Re: Vinnys' Salon, 3720 Coors Blvd NW
Grading and Drainage Plan
Engineer's Stamp dated 10-14-05 (G11-D66)

Re: Vincent Cano's Salon, 3720 Coors Blvd NW, Traffic Circulation Layout
Architect's Stamp dated 7-27-05 (G11-D66)

**Re: Vincent Cano's Salon, 3720 Coors Blvd NW, Traffic Circulation Layout
Engineer's Stamp dated 7-13-05 (G11-D66)**

1 A1a TRAFFIC CIRCULATION LAYOUT

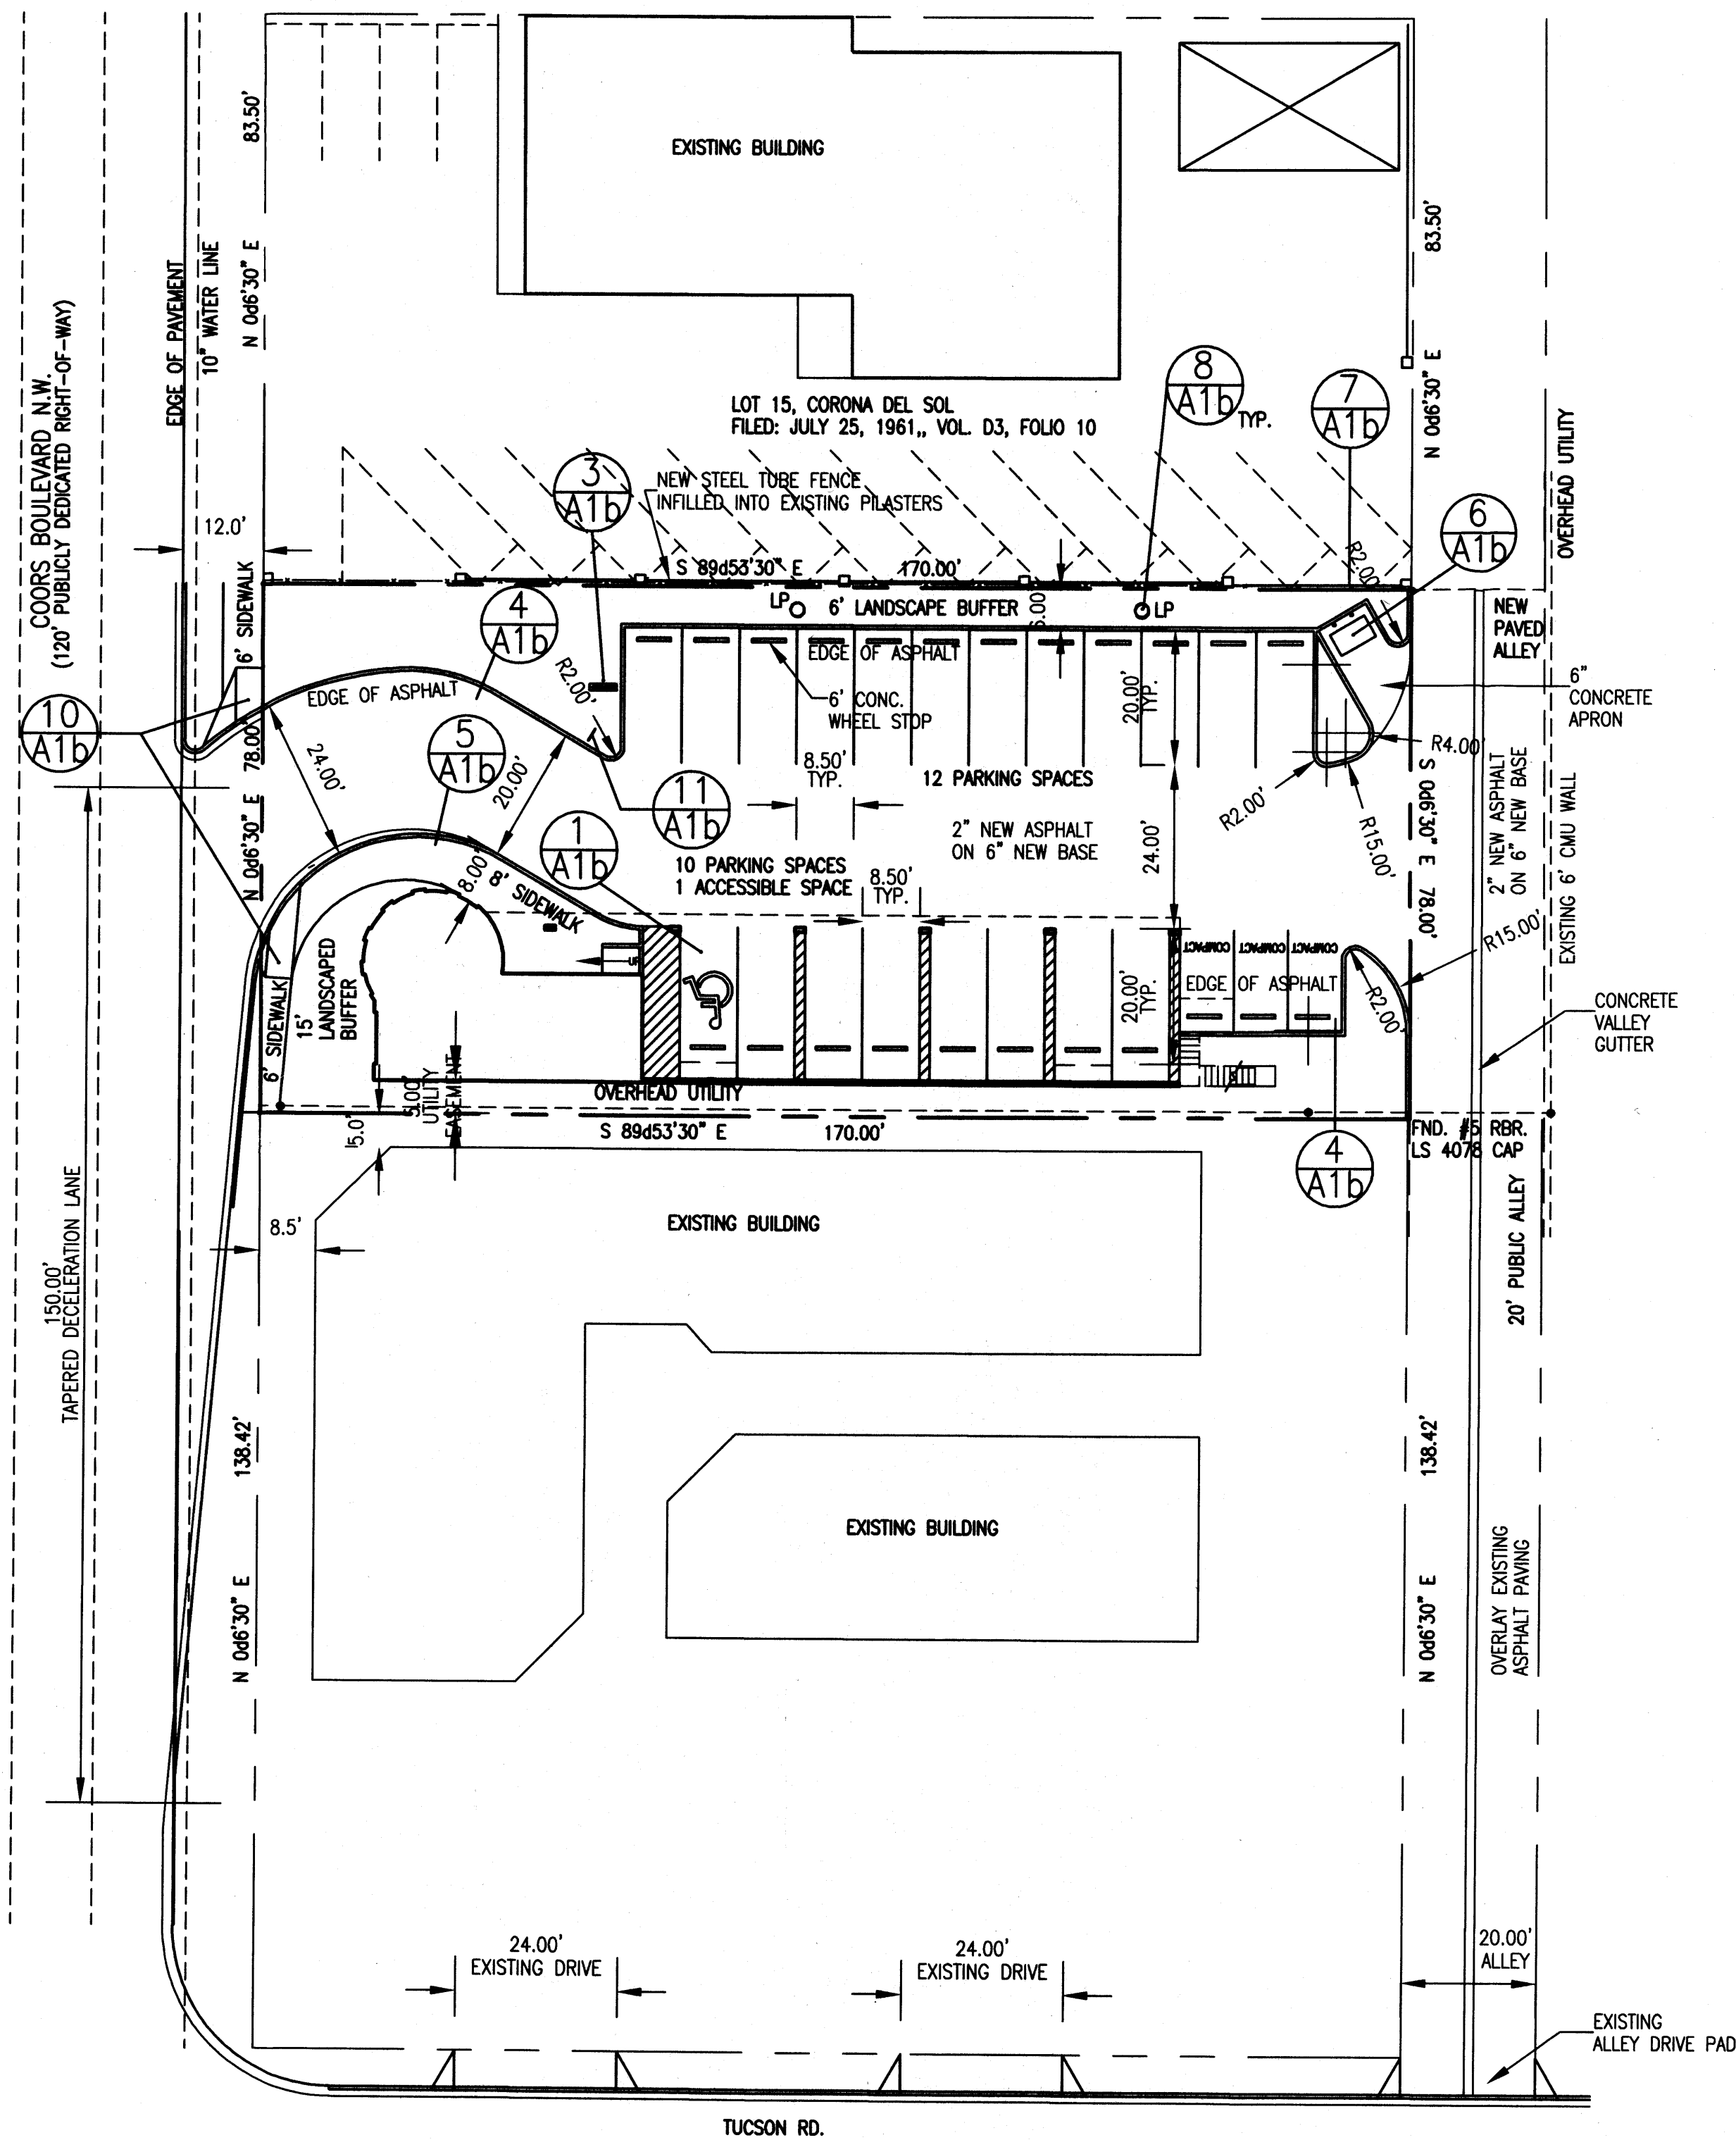
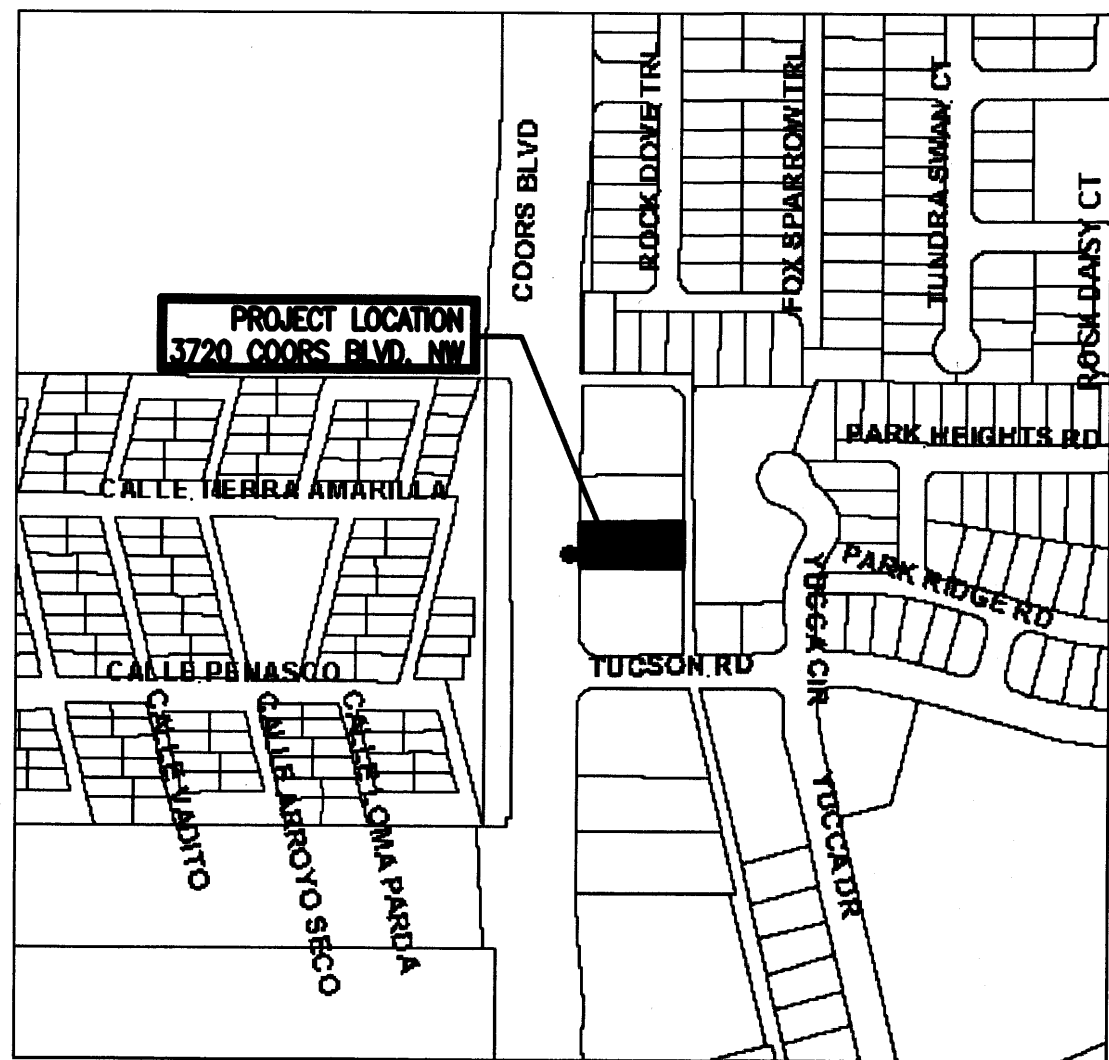
1. The handicapped spaces must include an 8-foot wide van access aisle; all other aisles should be 5 feet in width.
2. Show the extents of the proposed alley paving, referring to all appropriate City Standards. This work will be done under the City Work Order process. Please add a note to this effect.
